Response to Planning Application

Application ref: P/117/21/PL

Description: Construction of a new packhouse including relocation of parking area and landscaping. This site may affect the setting of a listed building and is in CIL Zone 5 (Zero Rated) as other development.

Location: Seftor Farm Pagham Road Pagham PO21 3PX

Architect's Illustrative Site Layout

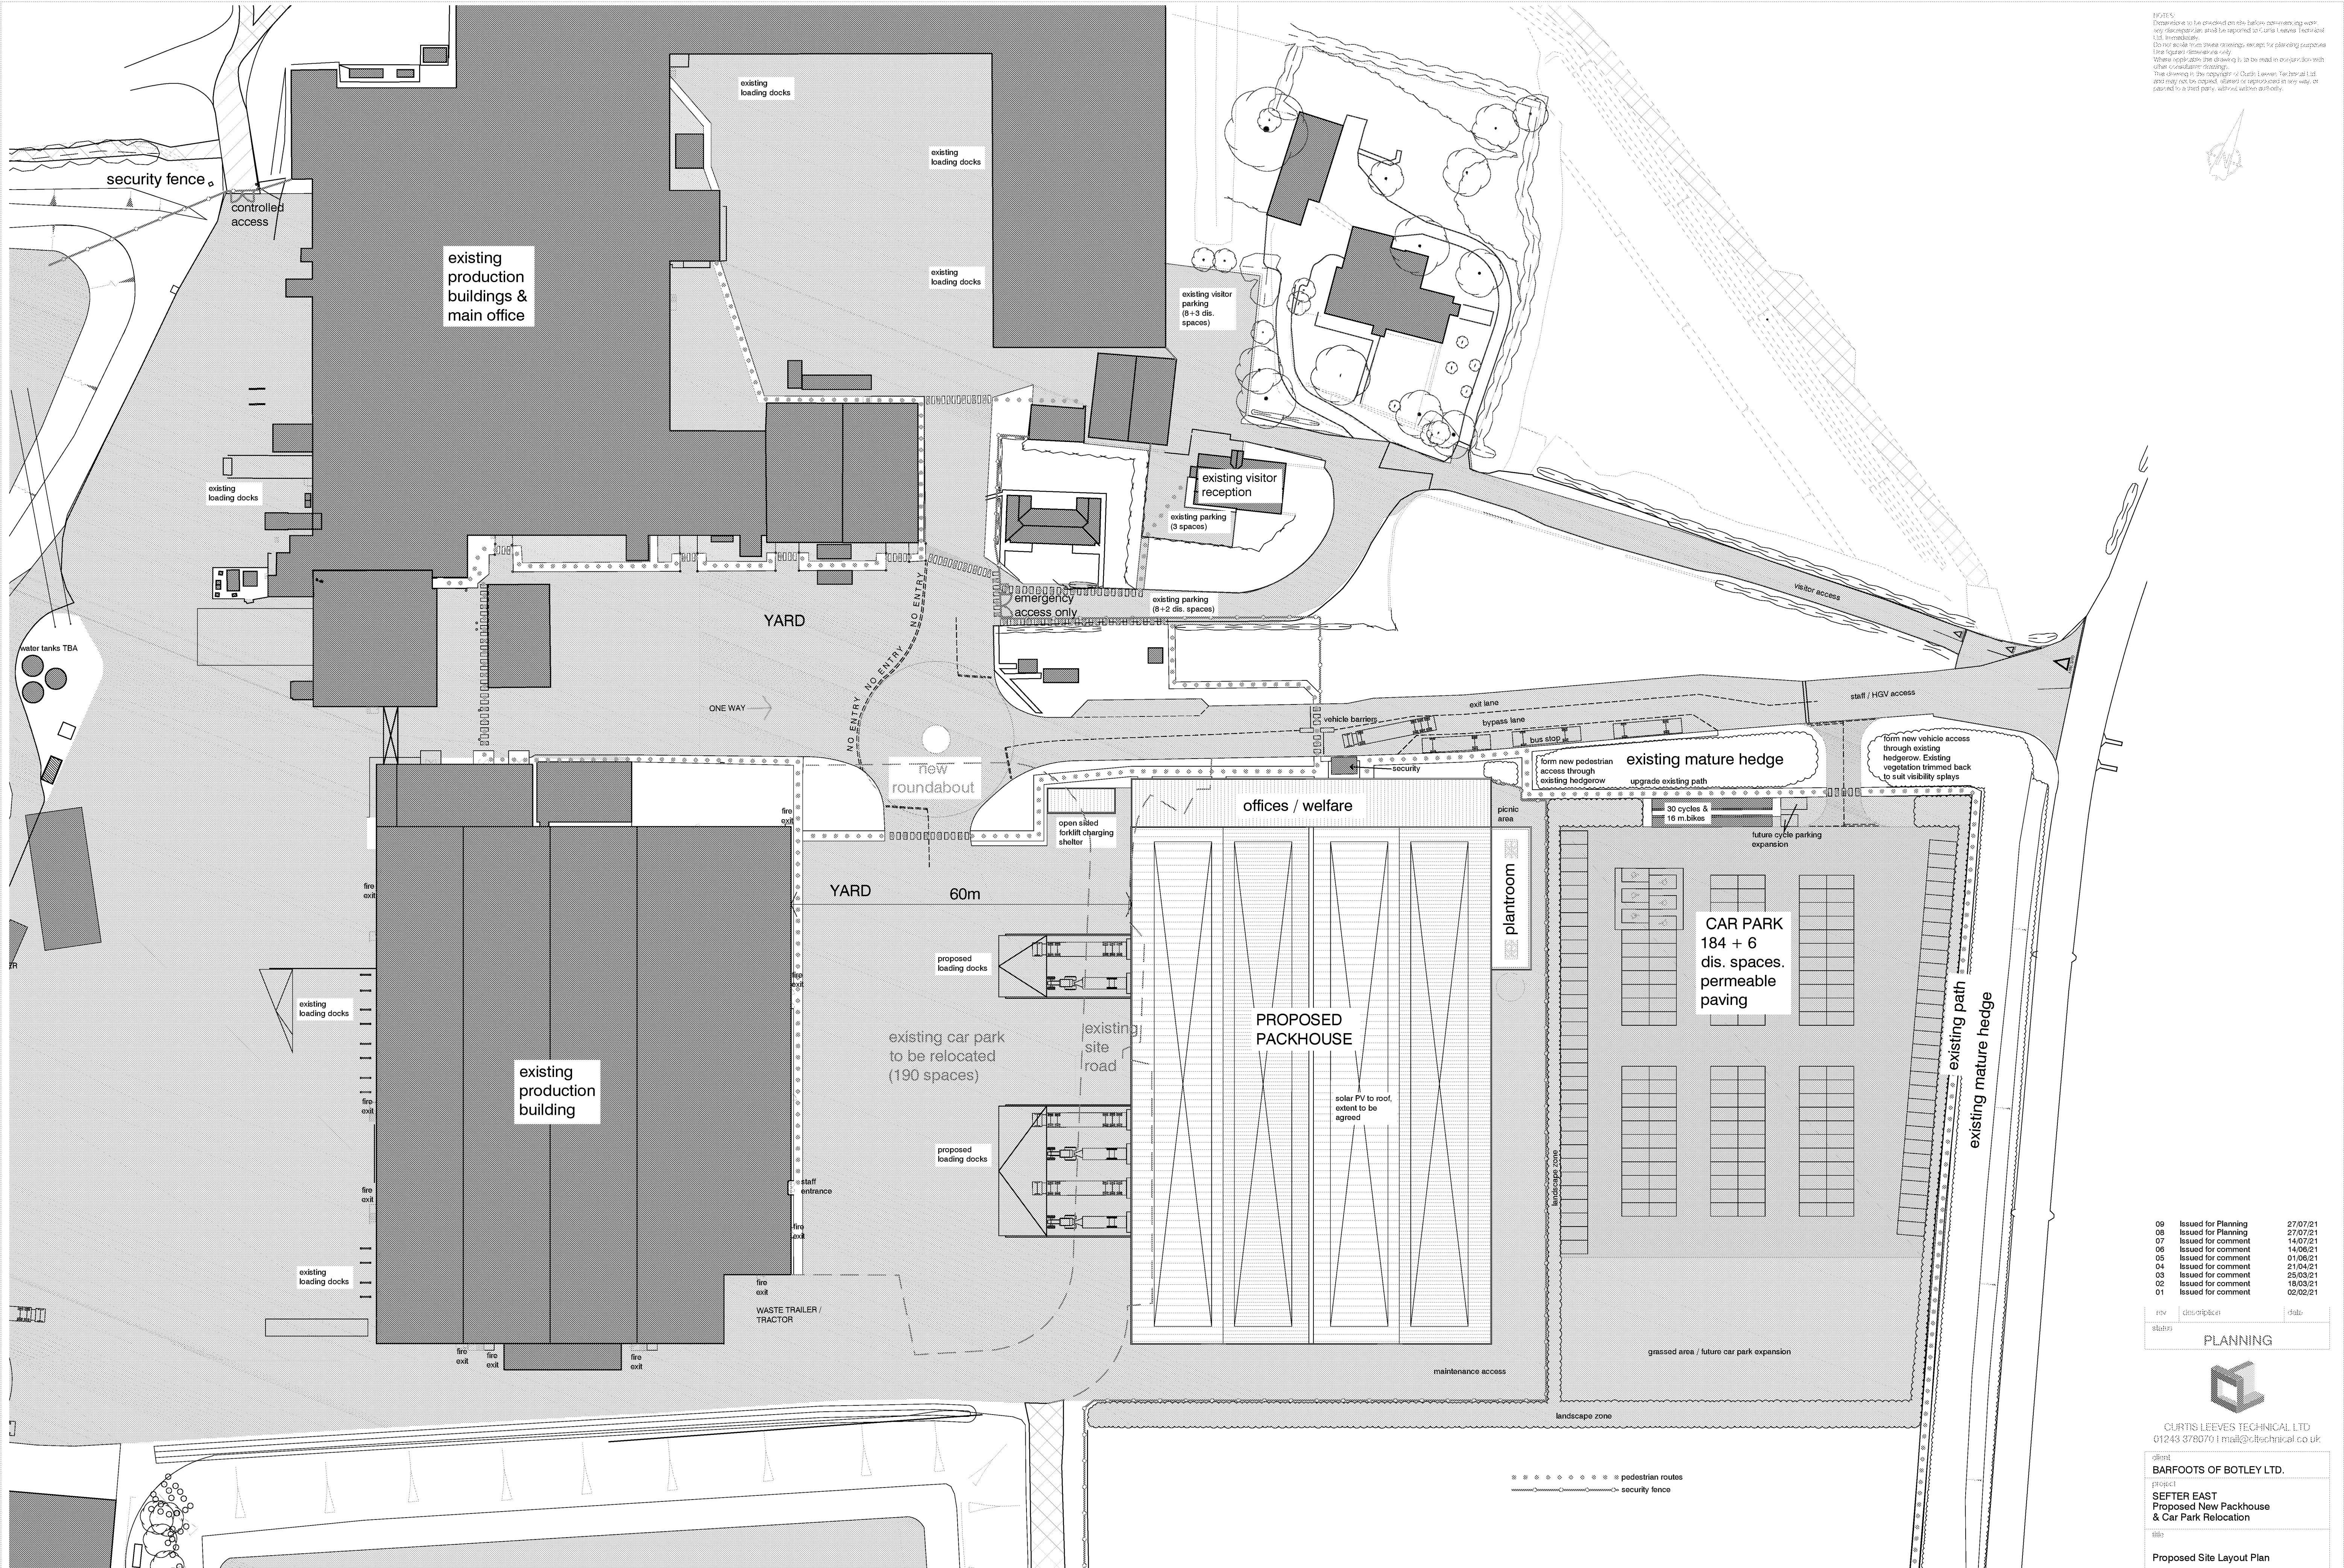
The 005 Rev 10 proposed site layout Plan makes reference to an indicative landscape zone to the south of the proposals, this is not shown in detail and will be required to be submitted plan form detailing the proposals and biodiversity net gain calculations.

Further detail of the landscape provision for the proposals as noted within the LVIA, needs to be submitted in plan form detailing the native planting proposed. This information needs to include species type with quantities, planting densities and size at time of planting.
